# KITITAS COUNTY

### MEMORANDUM

**TO:** All Staff  
**FROM:** Public Works Plan Review Team  
**DATE:** July 16, 2025  
**SUBJECT:** SP-25-00007 Suncadia Ph 3 Div 18

SUNCADIA P3D18B1

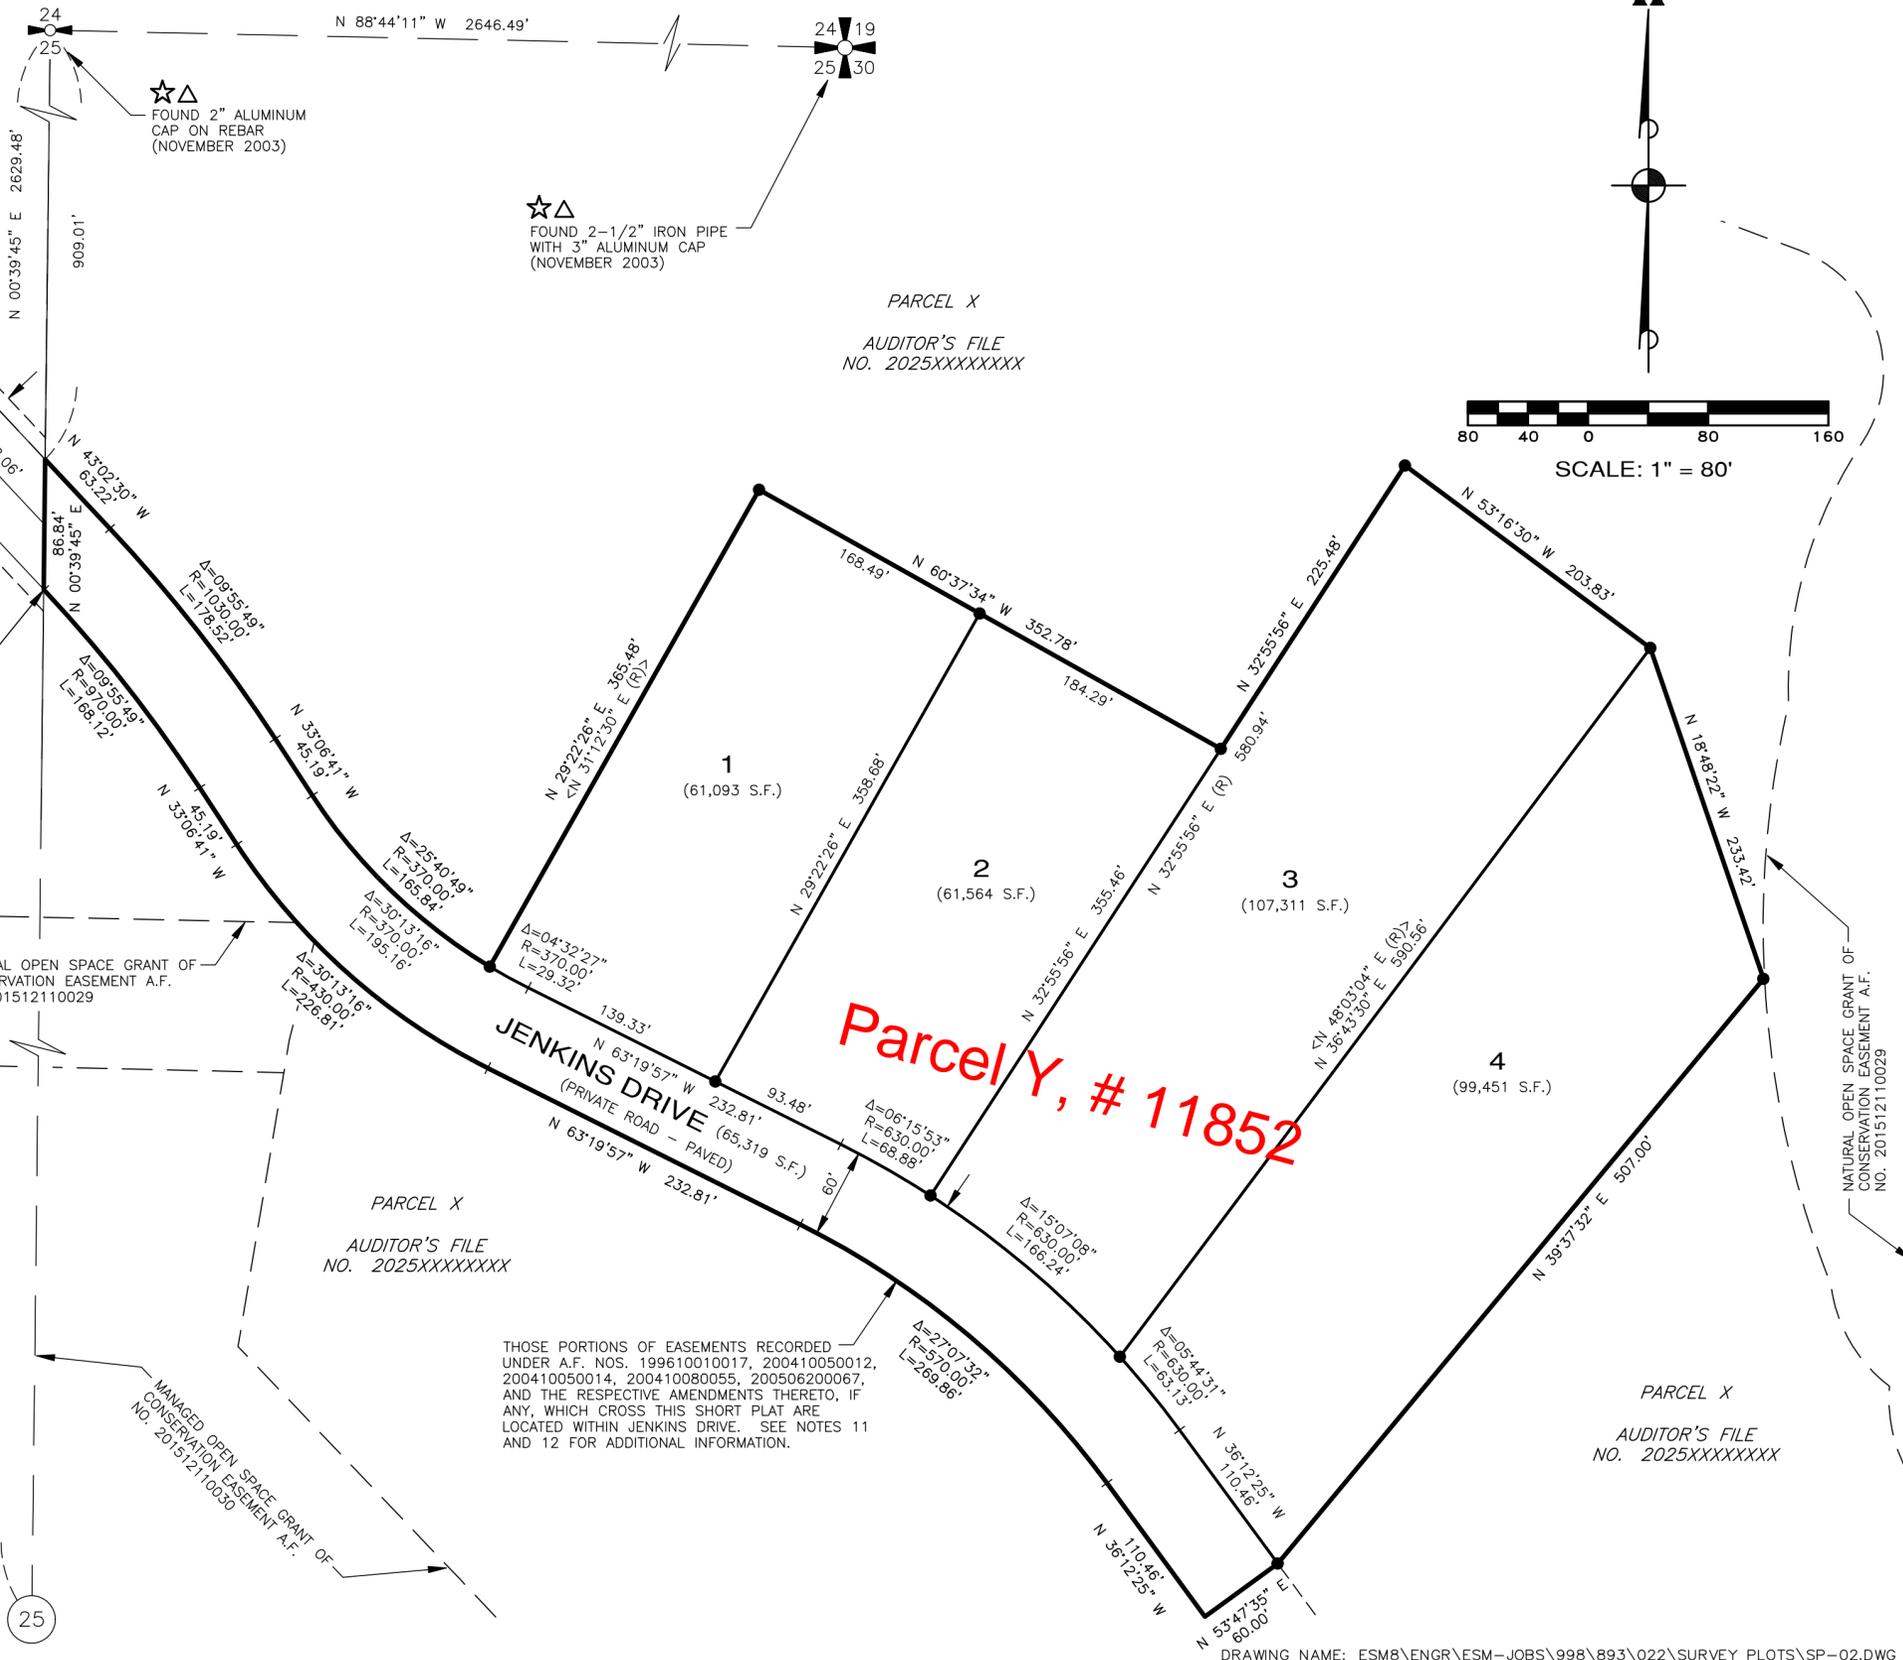
<b>SURVEY</b>	<p>NOTE: All survey comments are based upon the assumption that the previous record of survey (Application; BL-25-00006) will be filed PRIOR to preliminary approval of this Short Plat application.</p> <ol style="list-style-type: none"> <li>1. Add set corner symbol to the legend, together with a description of what was set.</li> <li>2. Please include Name and Address of Engineer of Record as well as the Date of the Survey (per KCC:16.12.020(5))</li> <li>3. Please provide an updated Subdivision Guarantee containing legal description that matches the legal description on the face of the Short Plat. (subject to recording of (BL-25-00006)).</li> <li>4. Existing Contours are to be shown, and sufficient data included to meet the requirements of WAC:332-130-145.</li> <li>5. Please Show "Short Plat" at the top of the page, together with a unique name for the subdivision. (JT)</li> </ol>
